Our Ref: M/42/17/HH 03-05-2017

Demolition of 1 No. shed & garage & erection of two storey side extension, driveway & entrance gates.

14B Sea Way Middleton on Sea

Thank you for your internet representation made on 30th May 2017 which has been recorded as '**an objection**' with the comments as follows:

Site Plan
Scale - 1:500

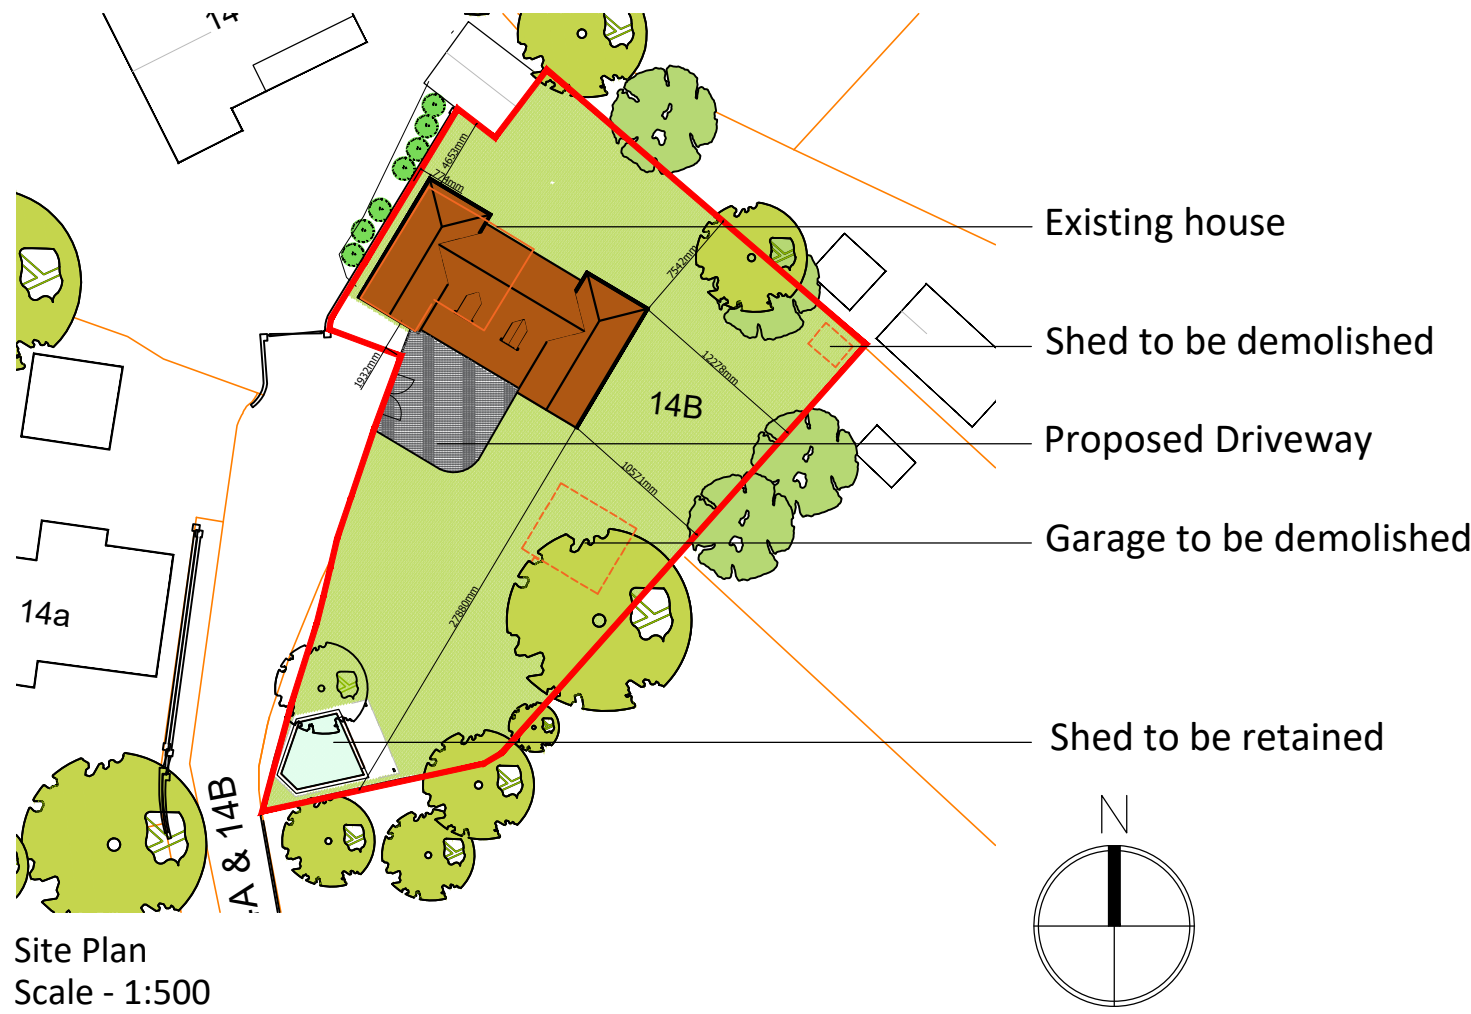
We believe that the proposed house is too large for the plot and would adversely affect the density of buildings in the immediate area. This is contrary to the Village Design Statement and the Village's place as an area of Special Character.

Proposed South East Elevation
Scale - 1:100

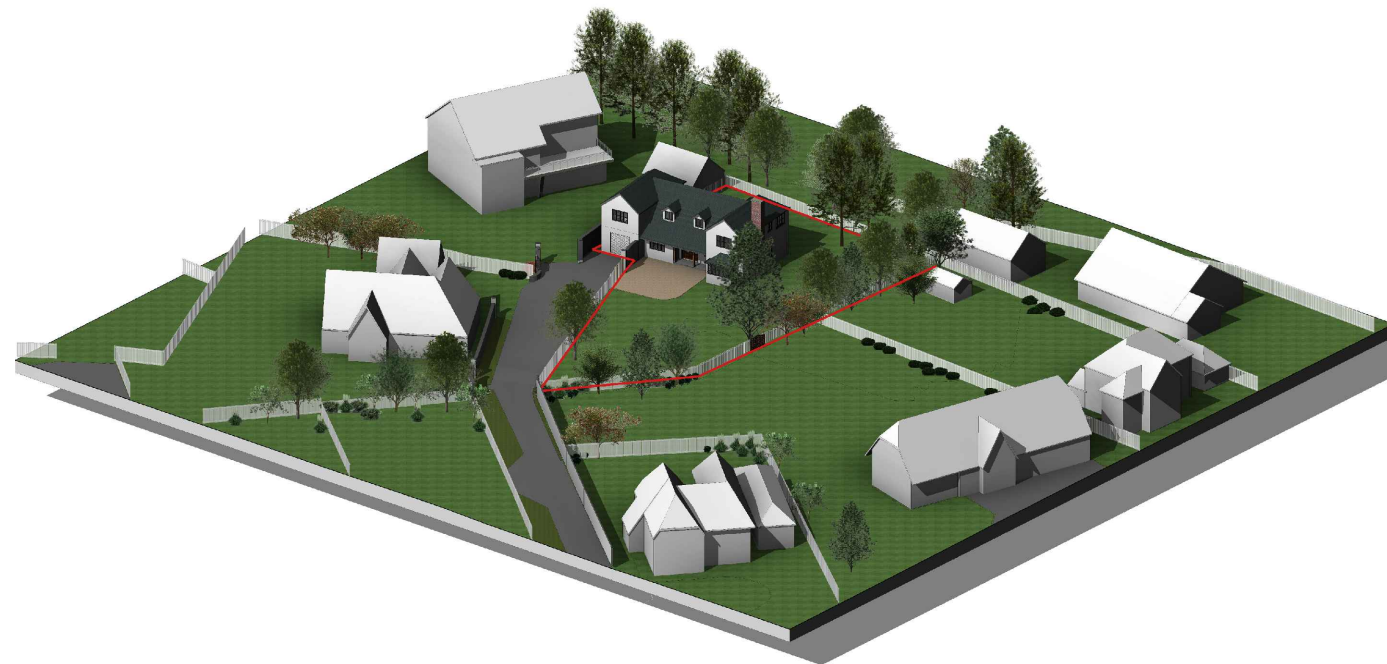
The design of the SE elevation means that 5 windows (3 on the first floor) directly overlook our property, with no shielding by trees. Although trees are shown on the plans, most of these were cleared by the current owner in the last year, and several dead trees have been removed. Any further removal of trees on the boundary would heighten the feeling of overcrowding and loss of privacy.
